Our Ref: EP/36/19/HH
Your Ref:

Development Change of pitched roofs to full gable roofs, new mono-pitch dormers to front & rear elevations on main dwelling & change of existing annexe roof to split mono-pitch roof.

Location 9 Myrtle Grove East Preston

Drawing: 320 – Proposed front gate and fencing

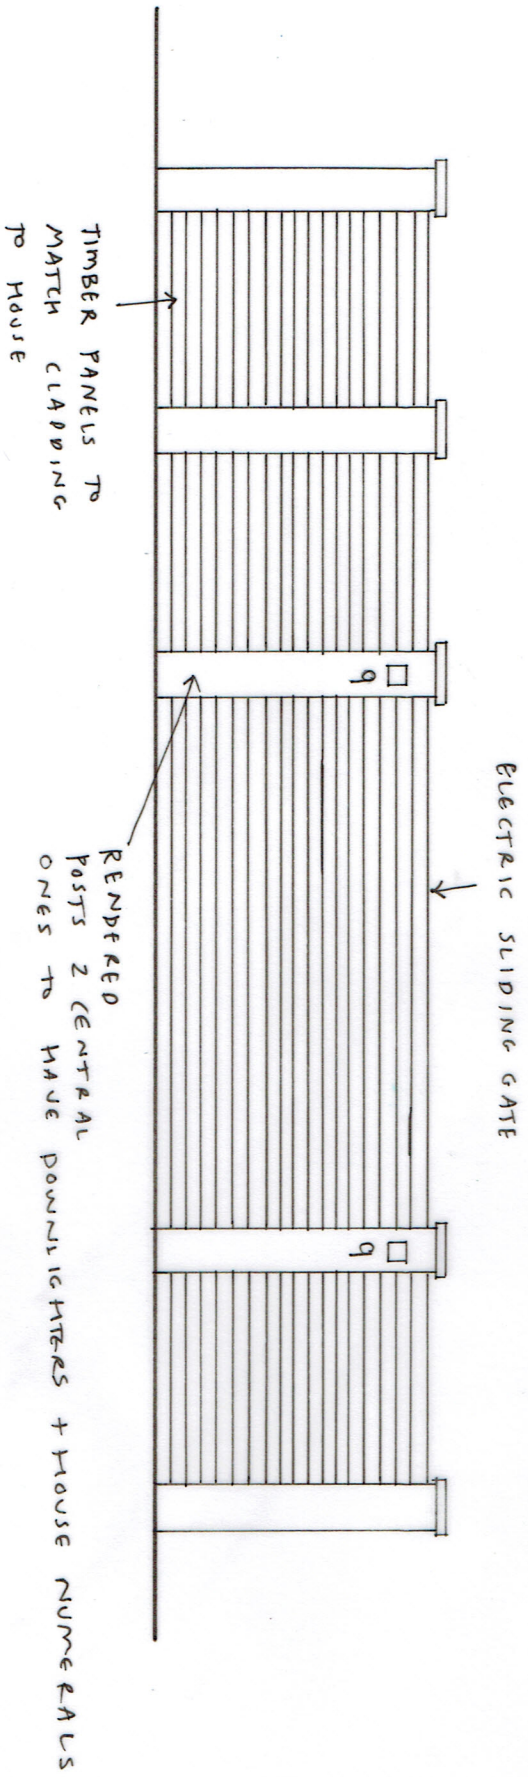
Please confirm if you wish the proposed new gate, fence and posts to be included in the application description. If the proposed gate, fence and posts are to be included in the application description, please provide an elevation.
